From: Jonathan Best <Jonathan.Best@arun.gov.uk>
Sent: 20 March 2026 15:24
To: Planning.Responses <Planning.Responses@arun.gov.uk>
Cc: Harry Chalk <Harry.Chalk@arun.gov.uk>
Subject: BR/5/26/PL

35 Glamis Street Bognor Regis PO21 1DJ.

I have reviewed this application with regards to ecology and Biodiversity Net Gain.

Recommendation: I recommend holding this application until further details are provided on the SSM BNG metric post development values.

DESIGN DETAIL / MATERIALS

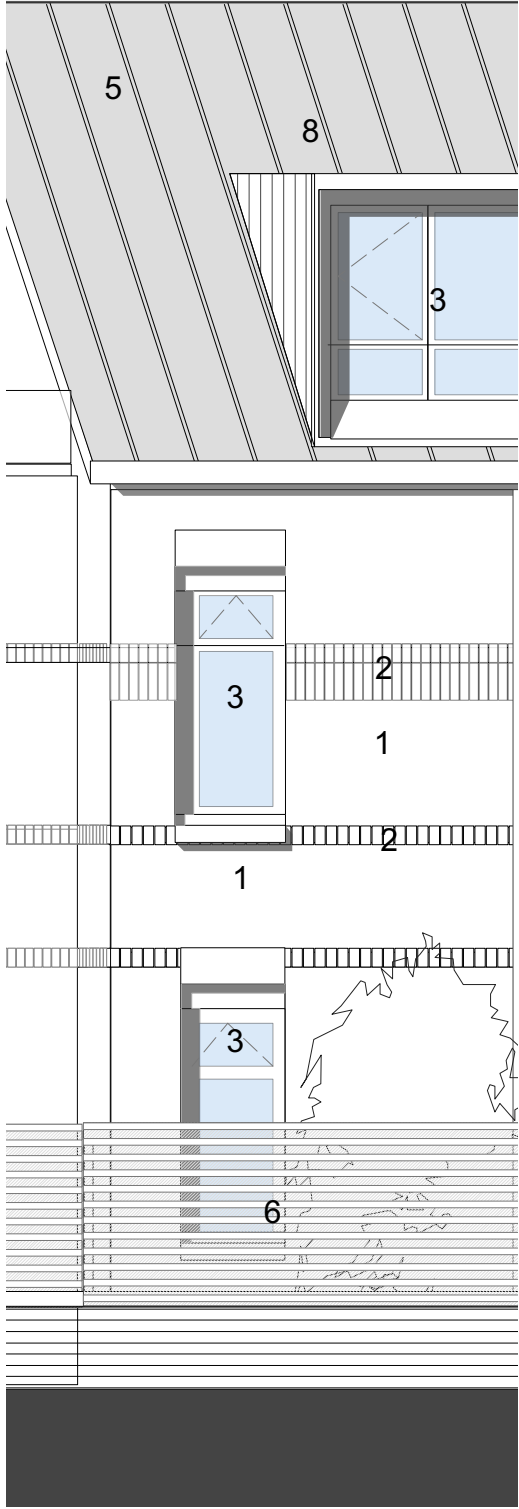
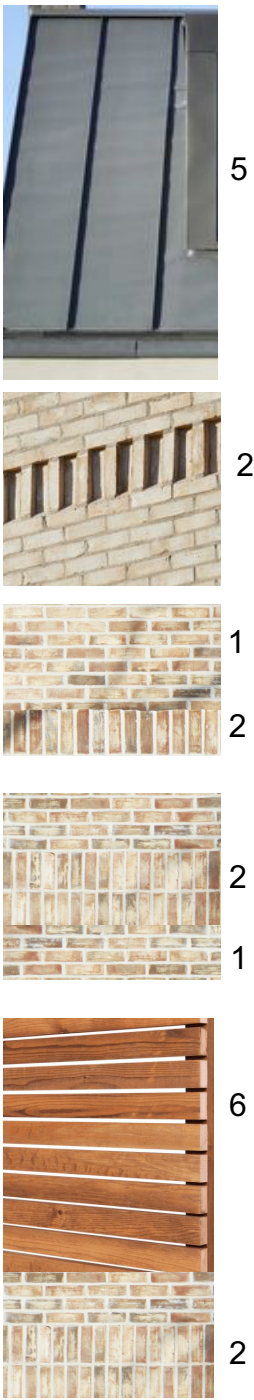
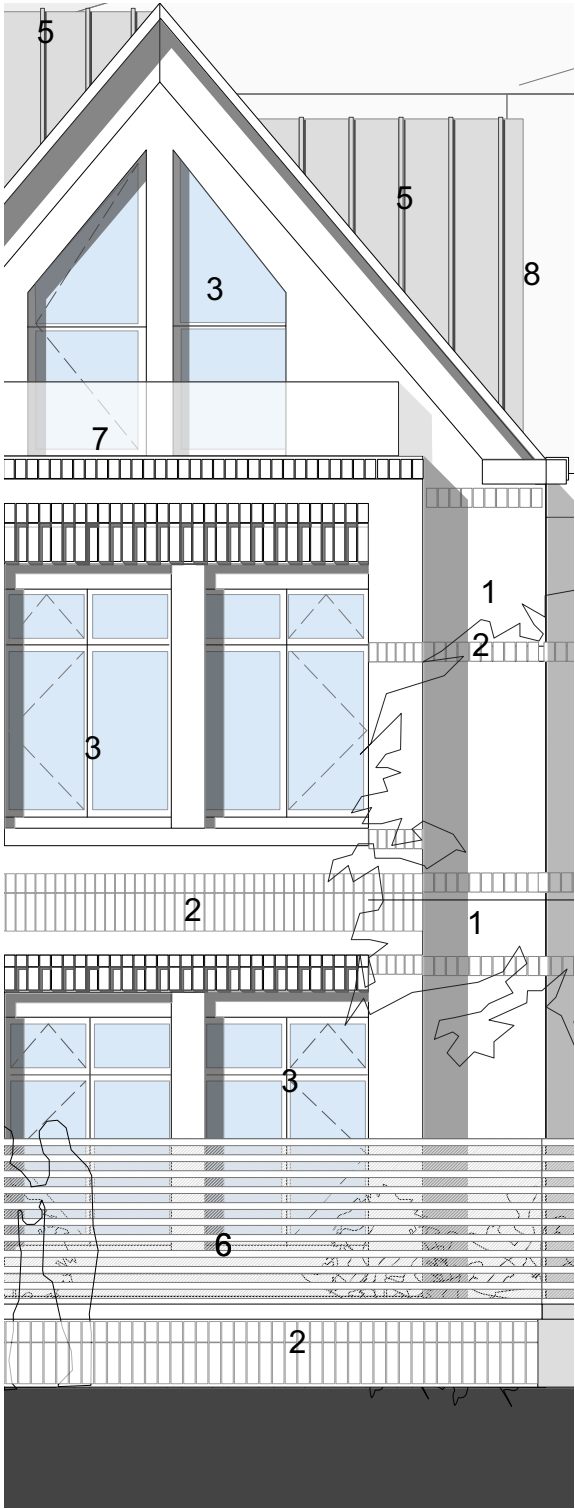
The provision of tree planting is welcomed but cannot count towards the post biodiversity unit value as it is located within private gardens.

Therefore, the gains recorded cannot be counted and consequently the gains are incorrectly calculated in this metric. A revised metric is required to show the post development BNG value. Offsite BNG may be required.
